**DCO Scheme: North Lincolnshire Green Energy Park**

**Our client: Network Rail Infrastructure Limited**

**Subject: Network Rail Infrastructure Limited's Response to First Written Questions dated 23 November 2022**

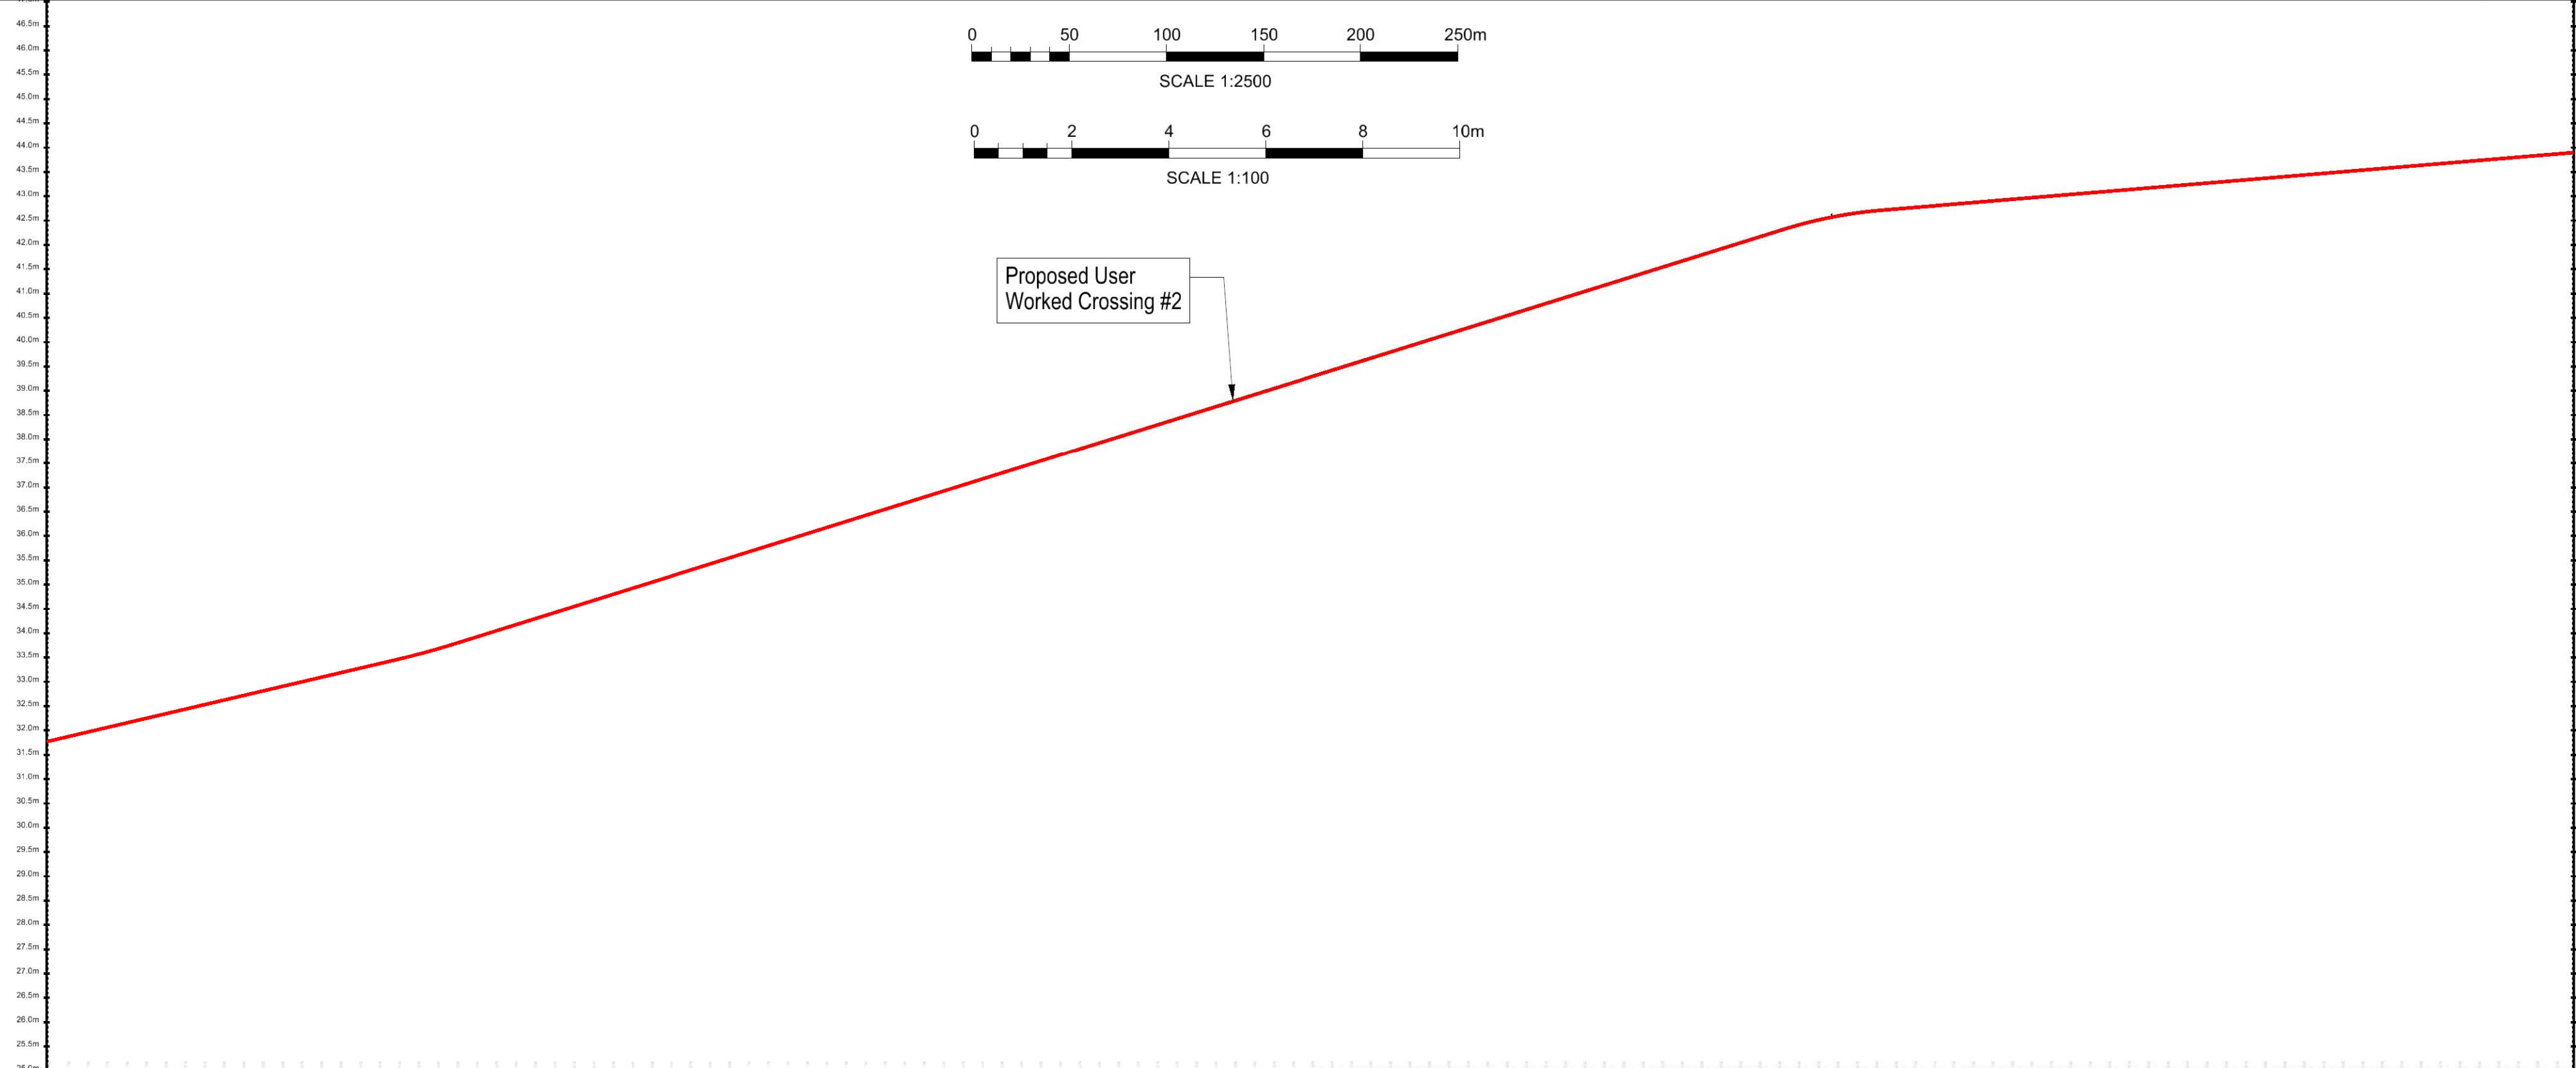
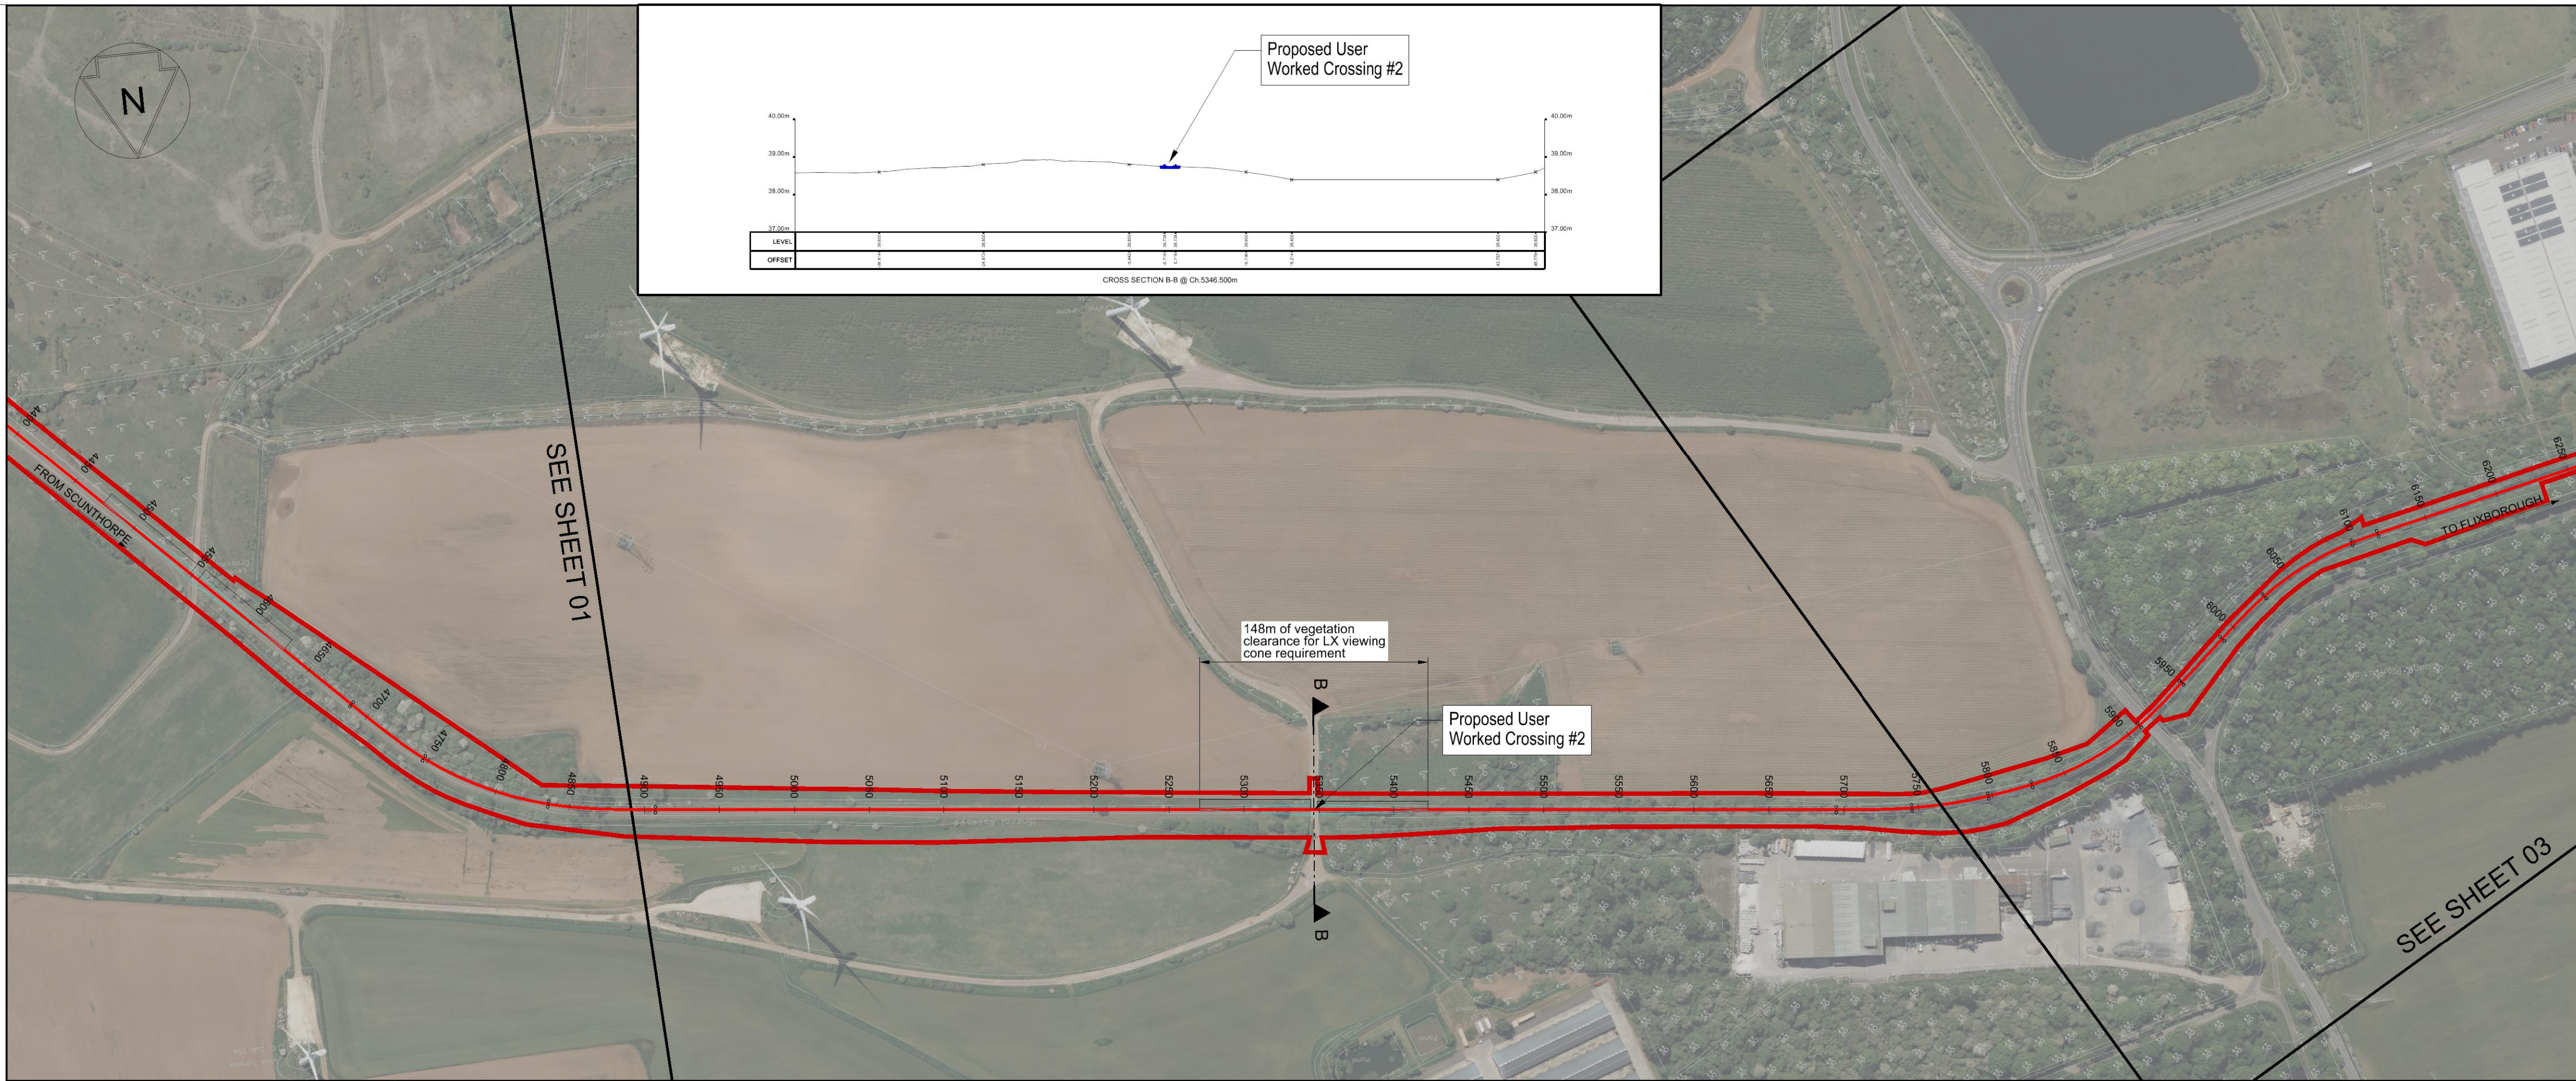
***i) Will either the footbridge(s) or level crossing require any form of illumination?***

**NR Response:** Our understanding is that the footbridges numbered #1 and #2 (as shown on Sheet 3 at Appendix B of the Rail Operations Report (APP-045)) and user worked crossings numbered #1 and #2 (as shown on Sheets 1 and 2 respective of the Rail Operations Report (APP-045)) are to be provided as part of the private railway forming part of the DCO Scheme and do not therefore fall within or impact upon NR's operational railway.
